From: Simon Davis
Sent: 04 April 2019 10:51
To: Planning Scanning
Subject: FW: BE/131/18/PL

From: Simon Davis
Sent: 04 April 2019 10:51
To: 'Ben Daines'
Cc: 'Chris Barker'
Subject: BE/131/18/PL

I am proposing to agree all of the condition changes in the application covering letter. However, am also proposing some further changes to the conditions in part as a result of our drainage comments which state that conditions 9, 10 & 12 could be discharged for phase 1 if you were to submit a DOC:

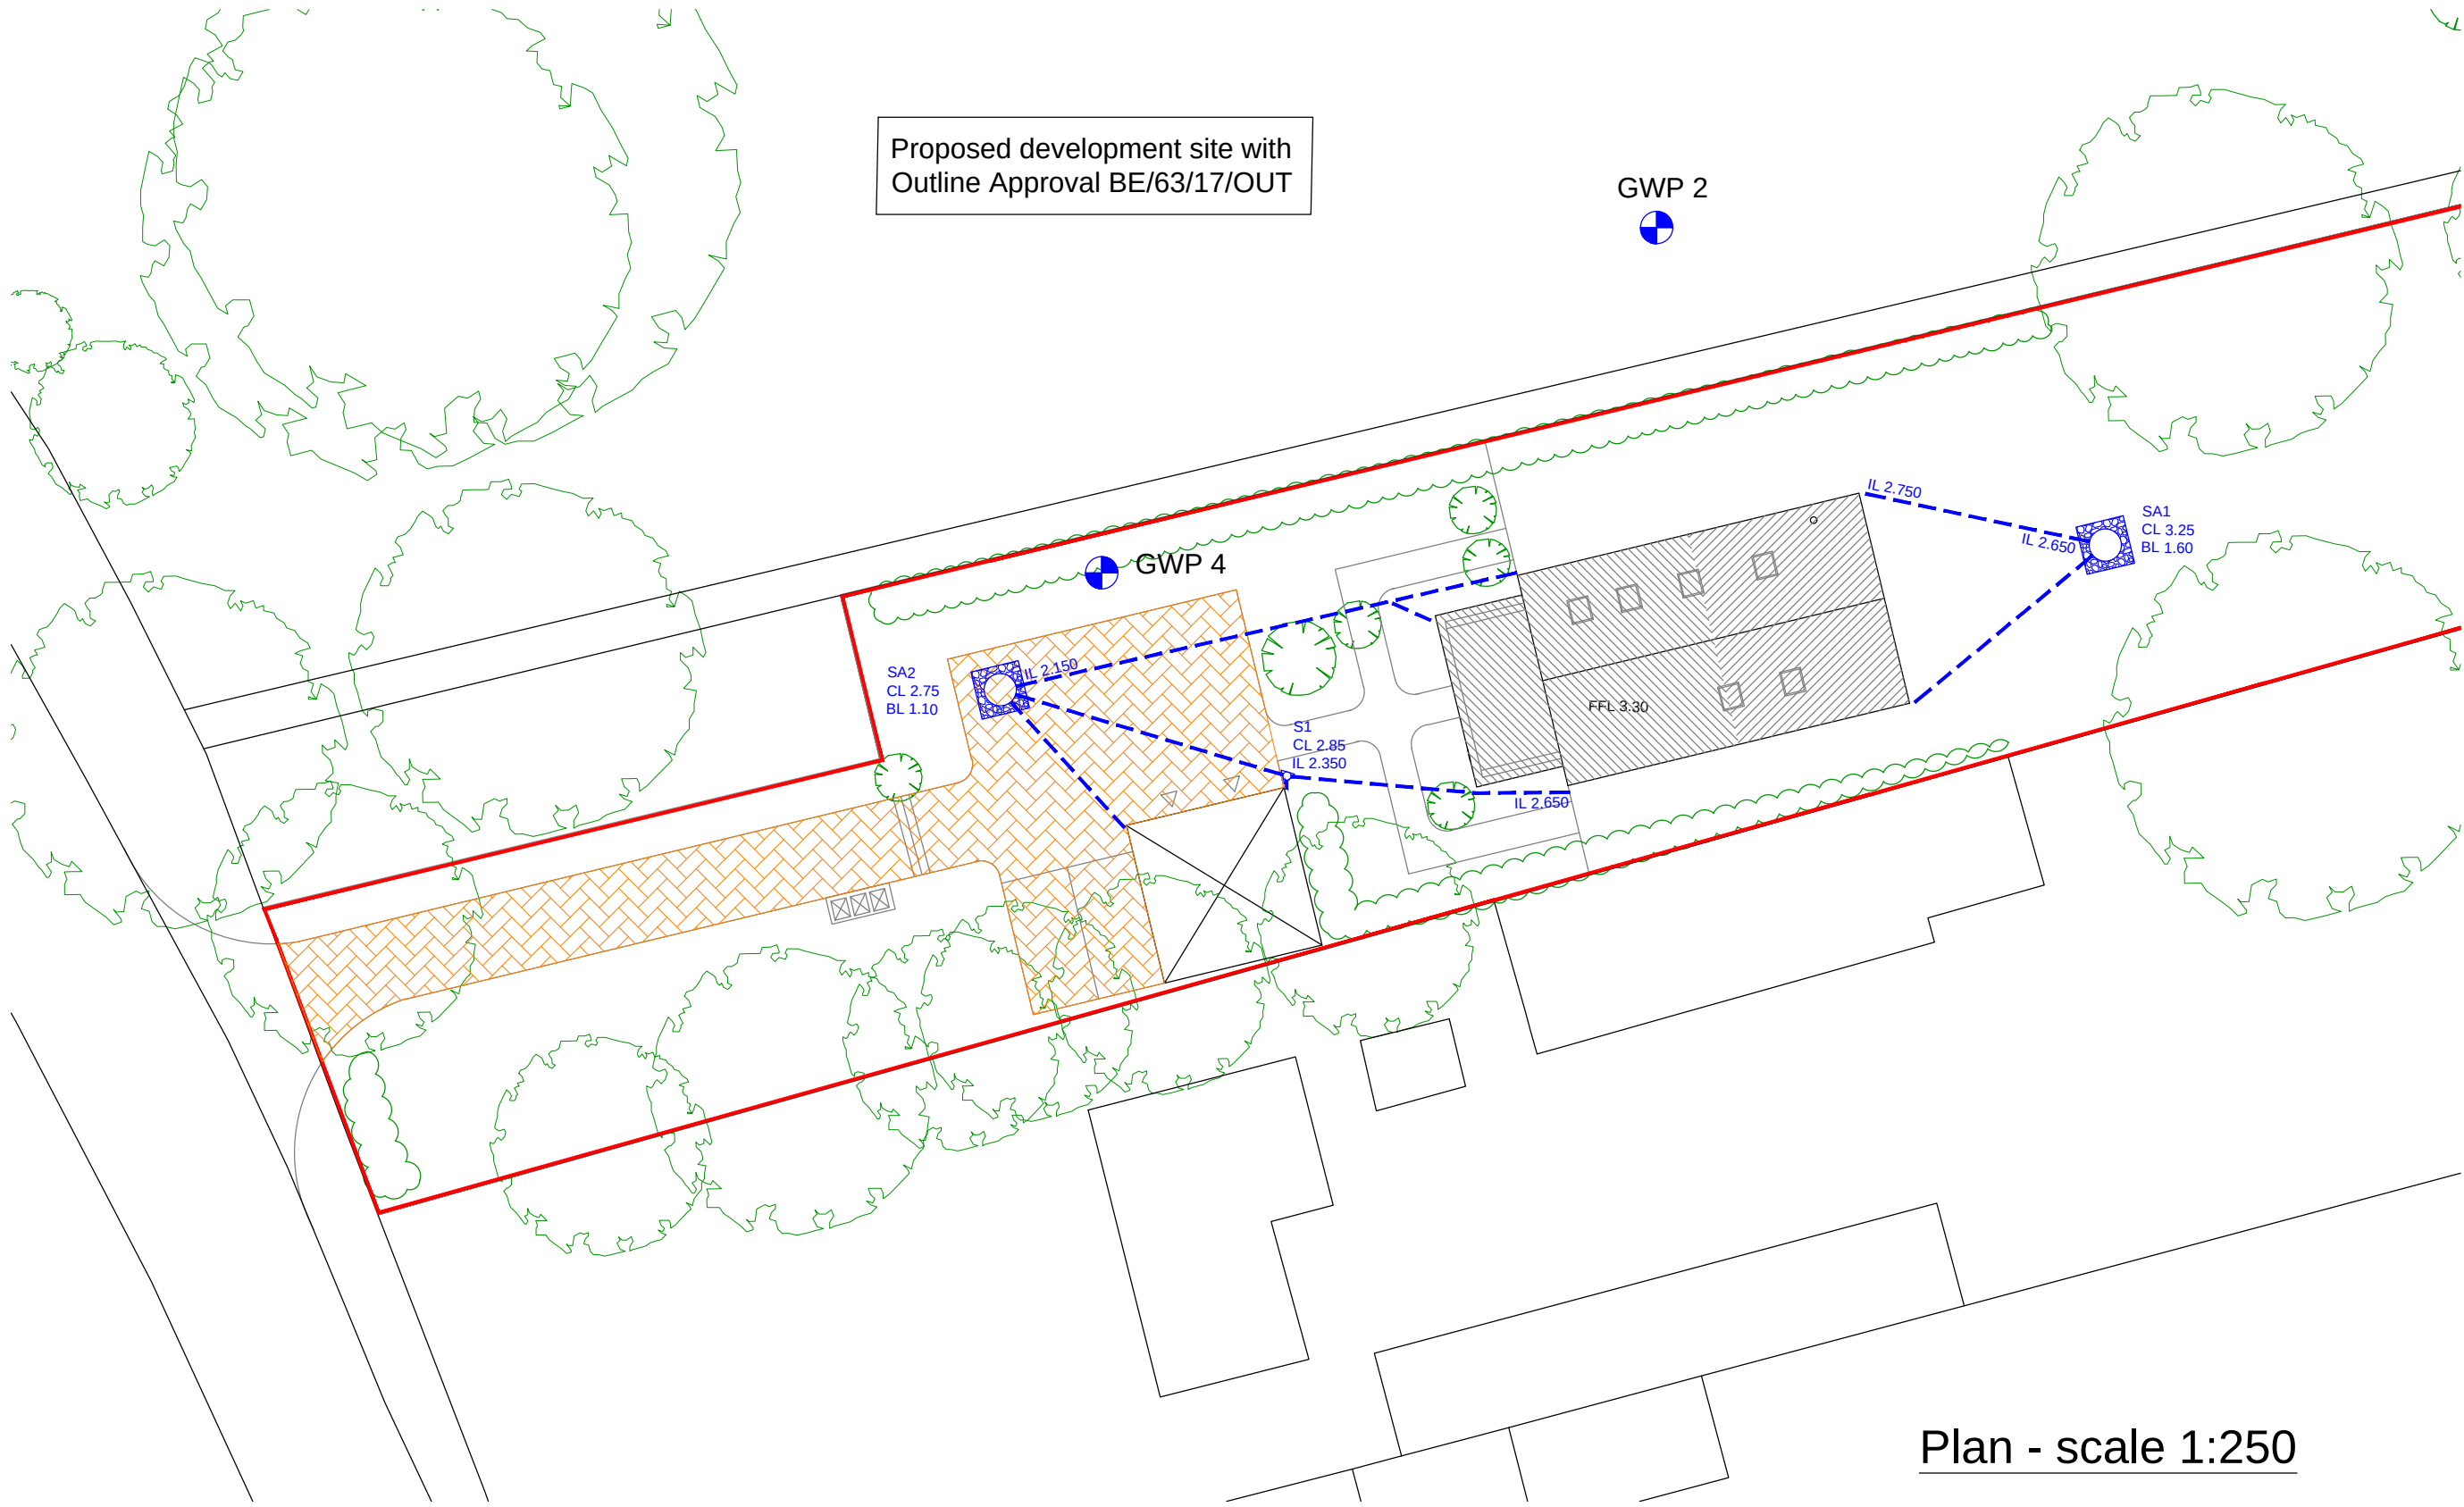
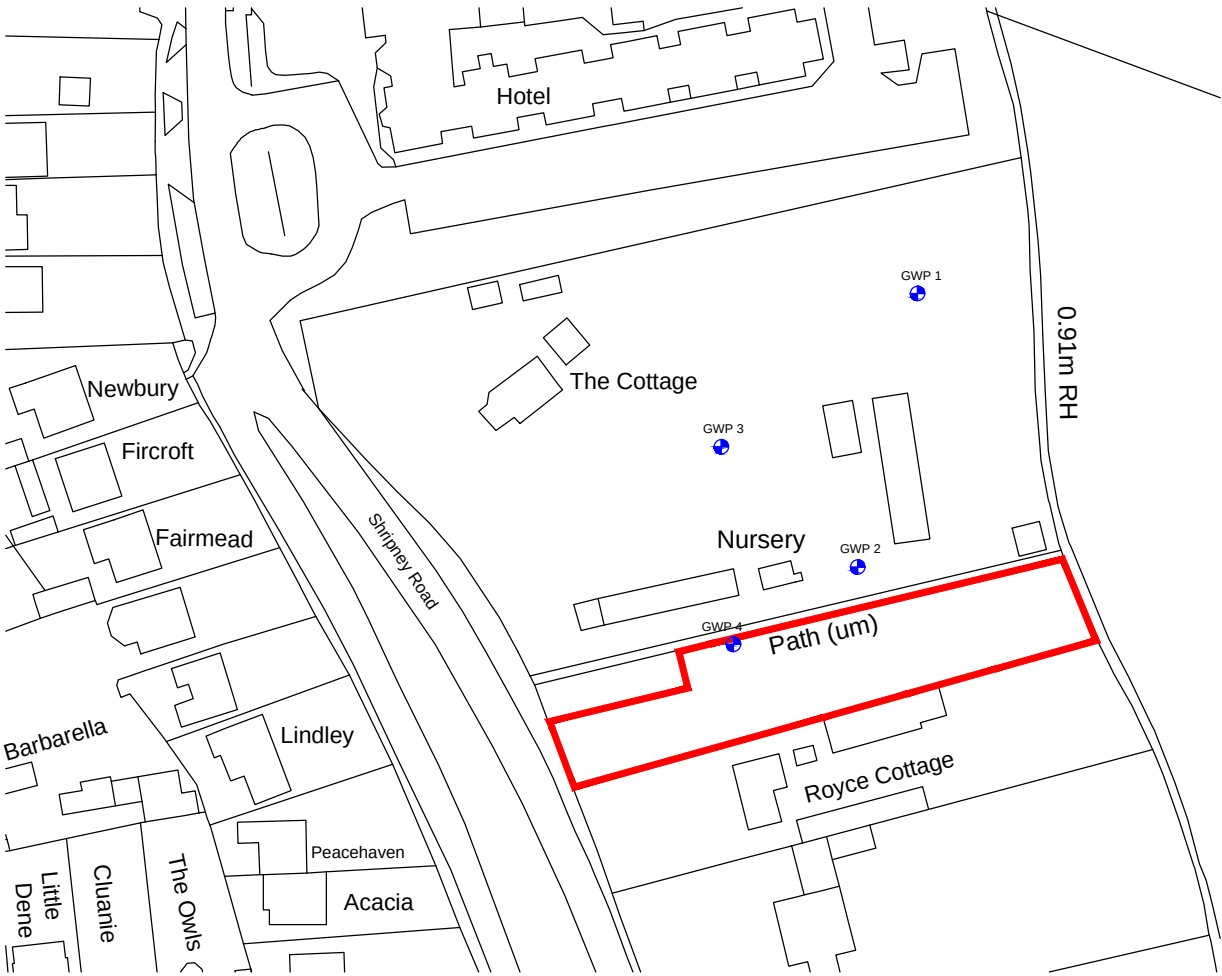
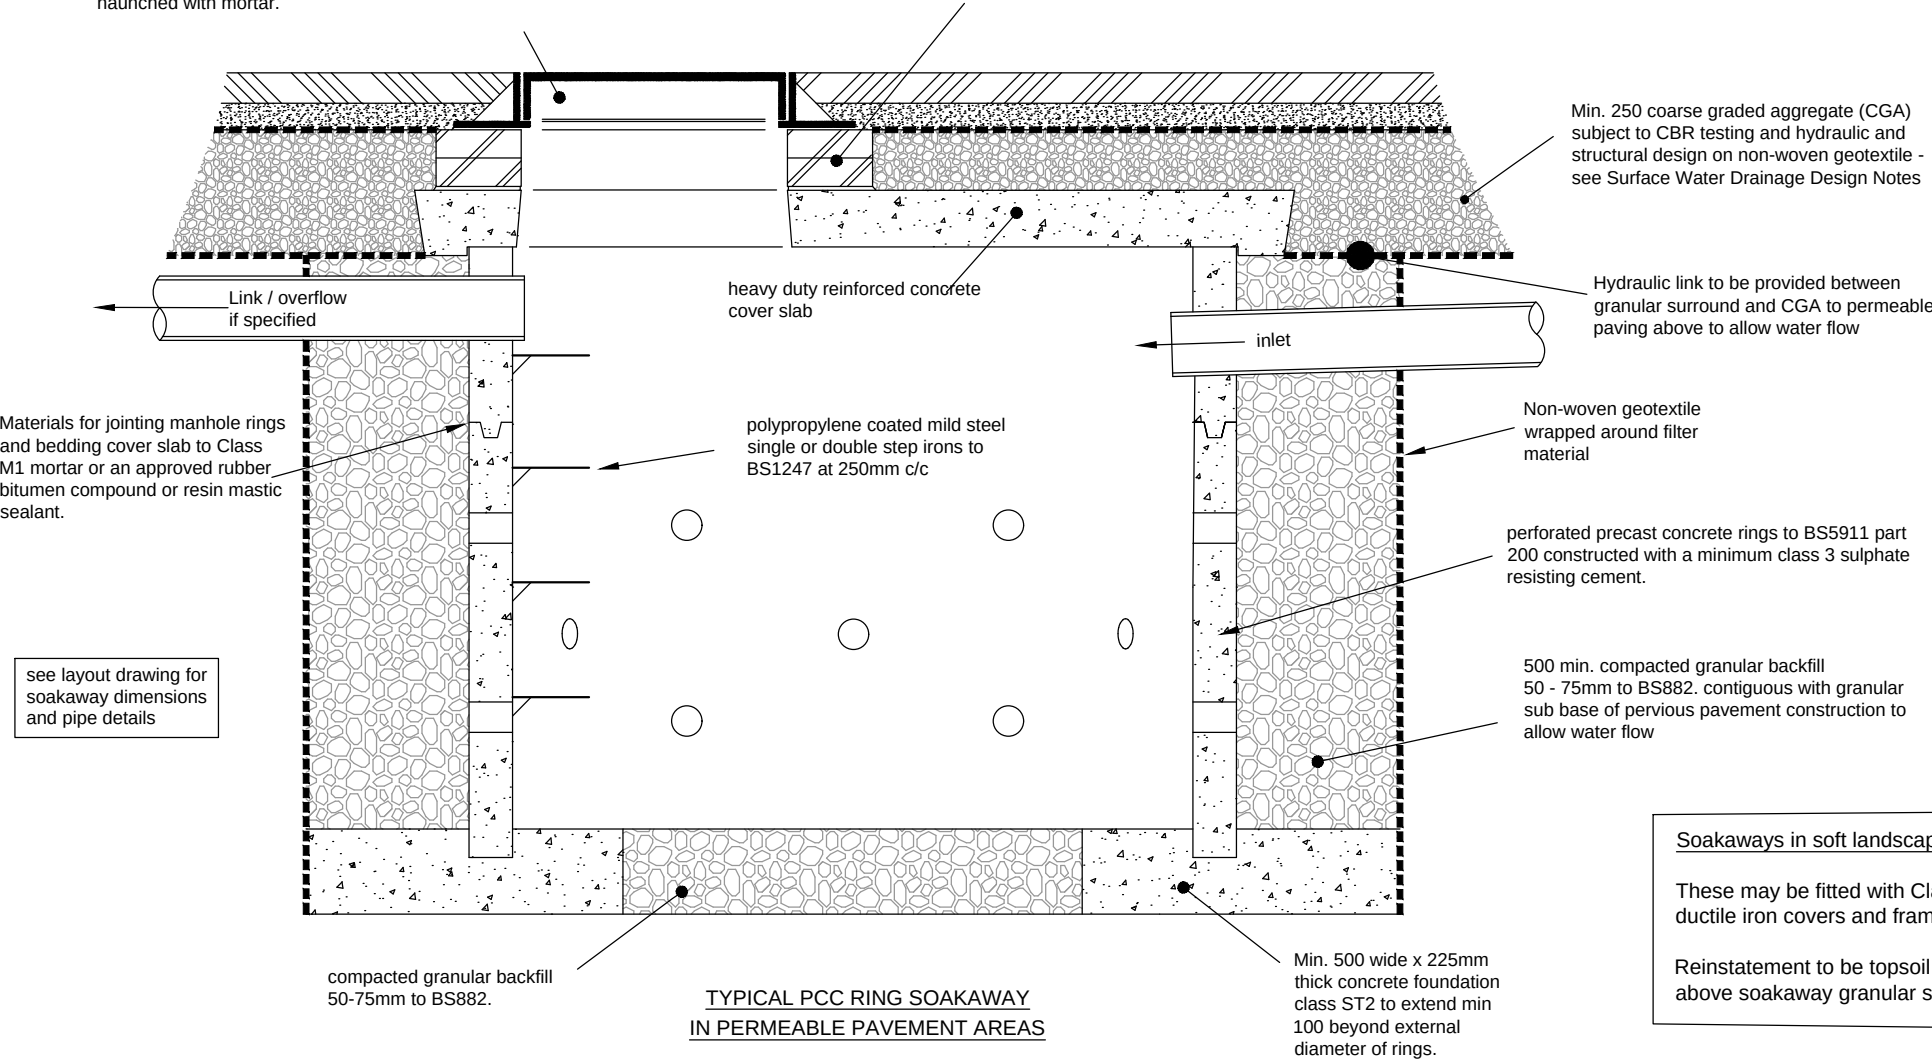
3. I am amending condition 9 surface water drainage to only relate to phase 2.
4. I am adding a new condition 6 to require that phase 1 is built in accordance with the approved surface water drainage scheme:

The development of phase 1 must be carried out in accordance with the approved phase 1 surface water drainage scheme shown on drawing 1808/SK2 "Surface Water Drainage Layout" by Robert Clark Associates Ltd. The scheme must be implemented and fully operational prior to occupation of the new dwelling.
